The Sizewell C Project

**Natural England's Comments on Revision 2.0 Outline Vessel Management Plan**

Planning Inspectorate Reference: EN010012

24<sup>th</sup> September 2021

Plate 1.1: Extent of SPA

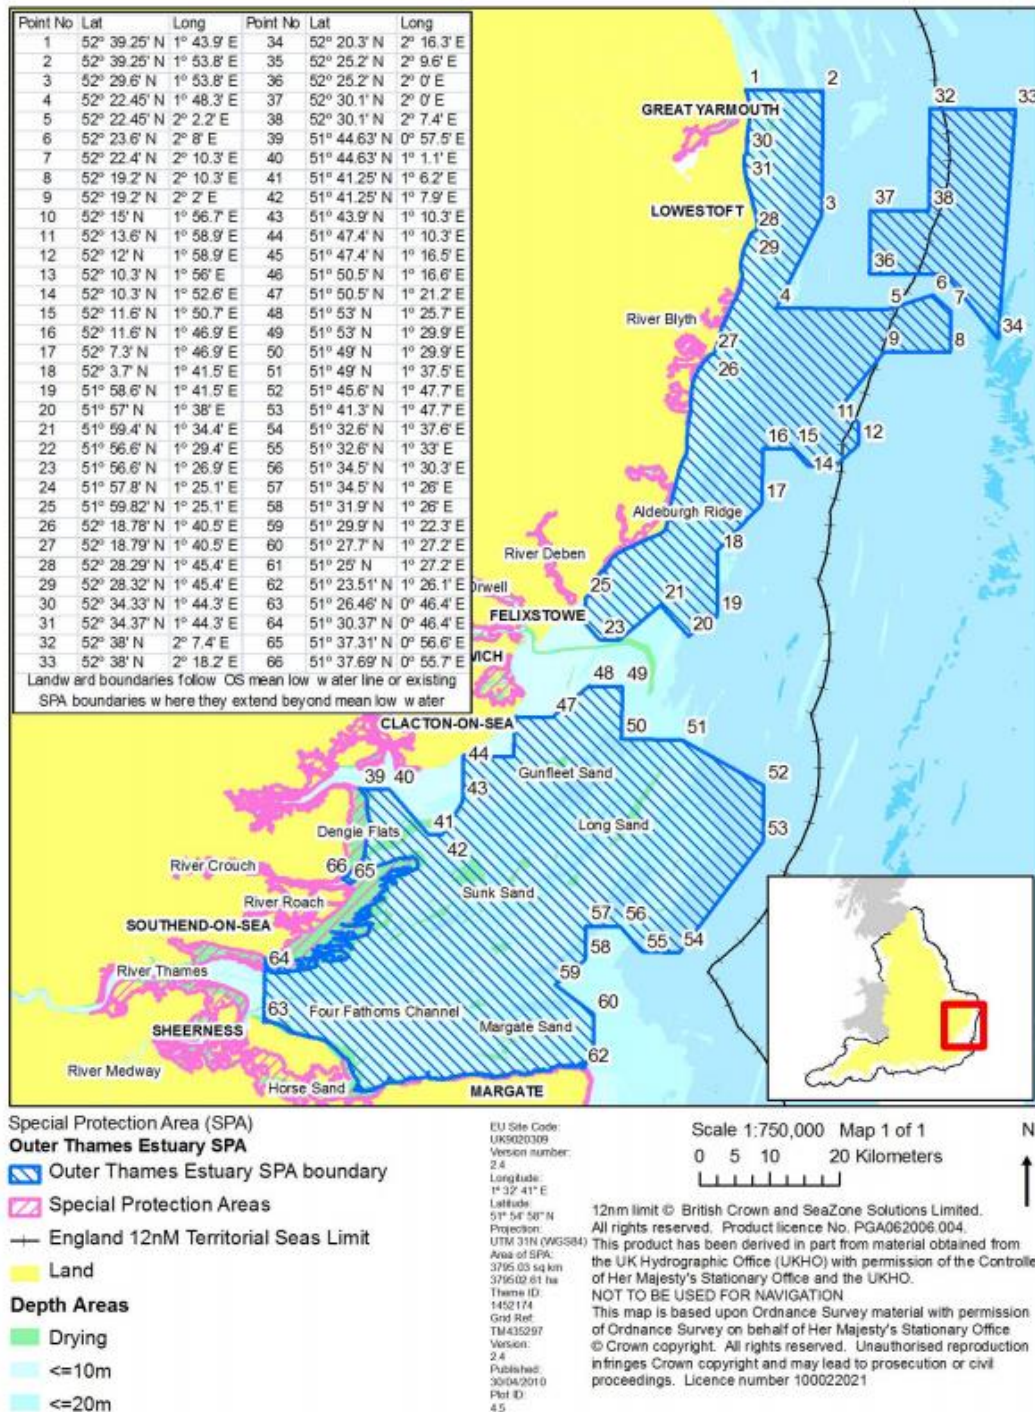
2.1.1	<b>Section heading and text here is obscured by plate 1.1 which means we have not been able to review</b>
Table 3.1	<p>It appears that winter vessel movements are now not being undertaken but have been 'retained for resilience'. There is no uplift in summer vessel movements. How is the lack of winter deliveries being accounted for the by the project, i.e. what is the proposal to replace the winter deliveries?</p> <p><b>Can it be confirmed that the project does not plan to undertake deliveries to the Marine Bulk Import Facility (MBIF/ Temporary BLF) in the winter season?</b></p>
	Note that each anticipated delivery tabulated represent two vessel movements. It would aid clarity if the number of vessel movements is tabulated, rather than this point being made in the text (3.1.5).

Plate 4.2: Indicative Delivery Routes – Local Ports

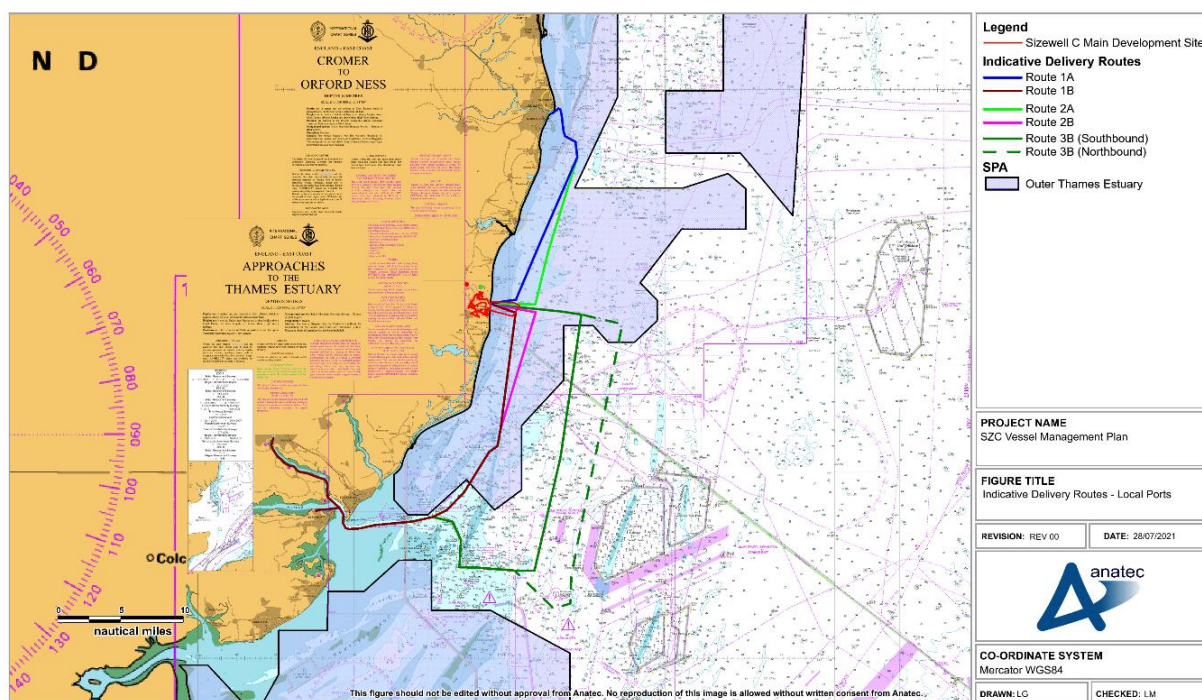
4.1.7 (Plate 4.2)	<p><b>We do not consider the use of Route family 1 to be appropriate as it is novel, situated farther inshore, and is likely to cause red-throated diver disturbance alone, and cumulatively with the nearby route that is already established.</b></p> <p>Route family 2 appears to represent a suitable compromise as it follows an existing route, albeit still almost entirely within the OTE SPA, it is likely that red-throated divers are already displaced from this route area.</p> <p>Route family 3 would be preferred to reduce impacts on the OTE SPA but Natural England note factors such as emissions are also to be considered.</p>

Plate 4.4: Indicative Delivery Routes - International

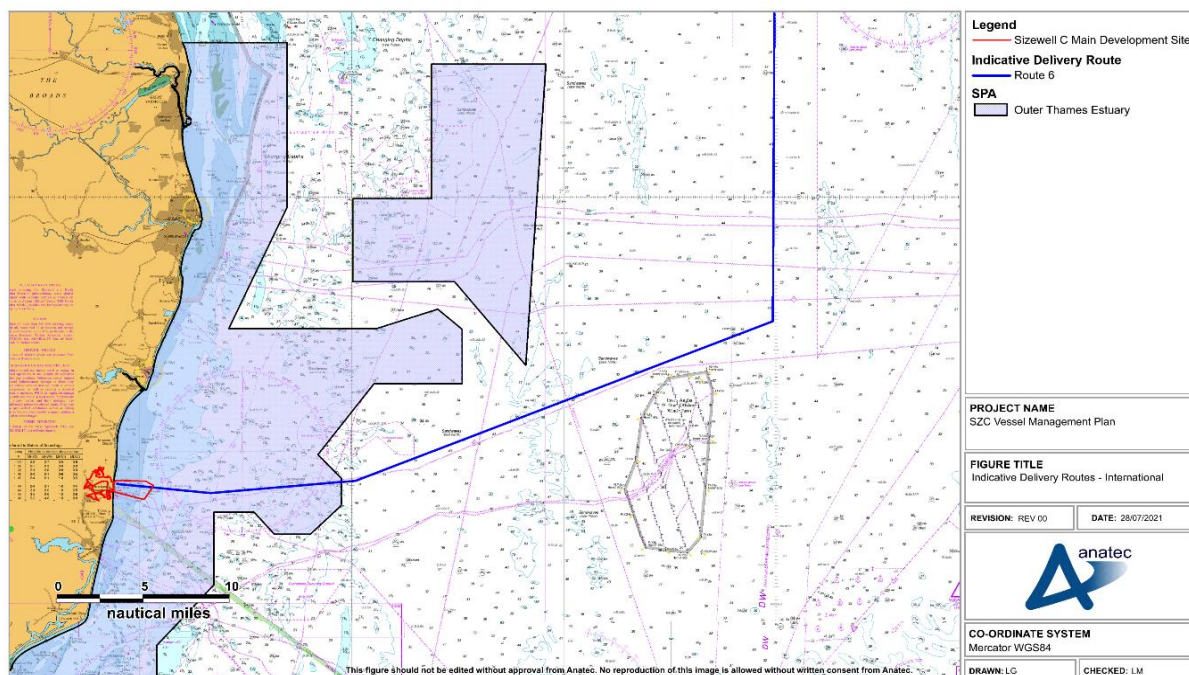
Par	Comment
Table 4.3 4.1.12	It is noted that the potential for winter deliveries is retained for resilience. However, we welcome the proposed reduction of winter deliveries to zero, and agree that <u>in this scenario</u> , there will be no disturbance impacts to red-throated divers at the SPA.
Plate 4.4	<b>Route 6 could be improved by entering the OTE SPA further to the south at the closest point at the boundary to the proposed development site</b> , thus reducing the amount of vessel time spent in the SPA.
